**Submission to Application Number** SSI-7485-Mod-2

**Assessment Type** SSI Modifications

**Development Type** Road transport facilities

Please find below my objections to Application Number SSI-7485-Mod-2 WestConnex - M4-M5 Link MOD 2 - The Crescent overpass and active transport links Constructing a grade separated vehicular overpass comprising a two-lane east-bound flyover separating the at-grade intersection at The Crescent and City West Link and relocation of the Rozelle Rail Yard Pedestrian and Cycling Green Link.

**Figure 4 | Proposed modification** (Source: Design Amendment Report)

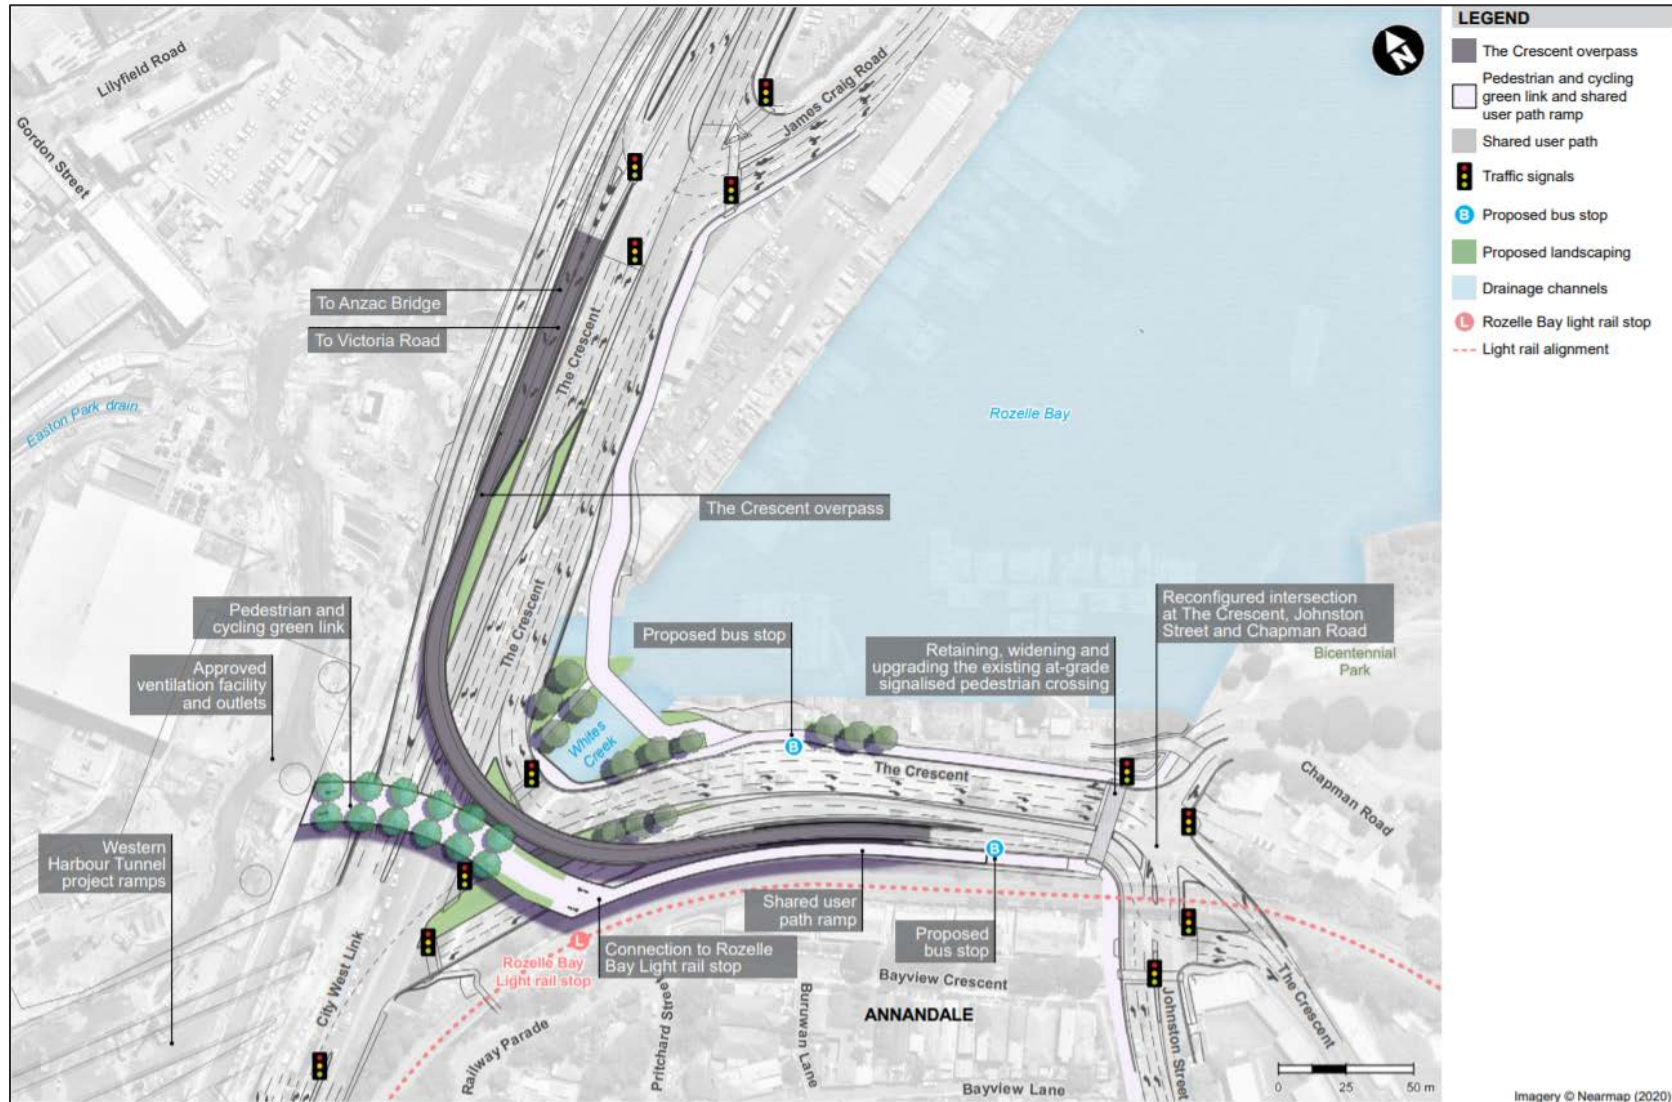
-the revised plans of The Crescent overpass have removed a vital proposed pedestrian and cycle “horseshoe bridge” that crosses the City West link

-created the road crescent road overpass (flyover).

The importance of being able to access and enjoy outdoor spaces has been especially evident during the COVID lockdown. We need to be increasing the connectivity of open space to make the most of this precious resource. The visual impact of the pedestrian horseshoe bridge is minor in comparison to the impact of the proposed road overpass.

**Figure 10 |** Indicative pedestrian and cyclists crossing over The Crescent and Johnston Street  
(Source: Response to submissions on Design Amendment Report)

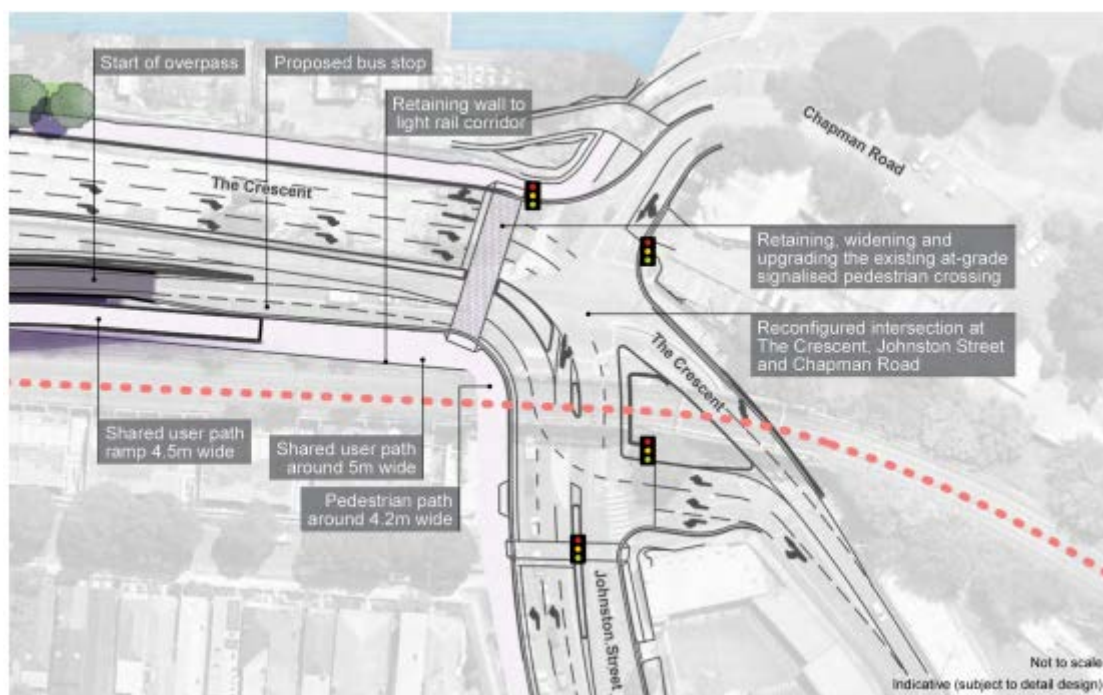
People on foot, bicycles, with prams, dogs and children to cross a wide, busy roads by these plans.

- pedestrians, dog walkers and cyclists crammed into a tiny space on the corner of Johnston Street and The Crescent as they wait to cross.
- People will have to wait for the lights to change allowing 90 seconds to cross – with everyone bunching up and not able to spread out.
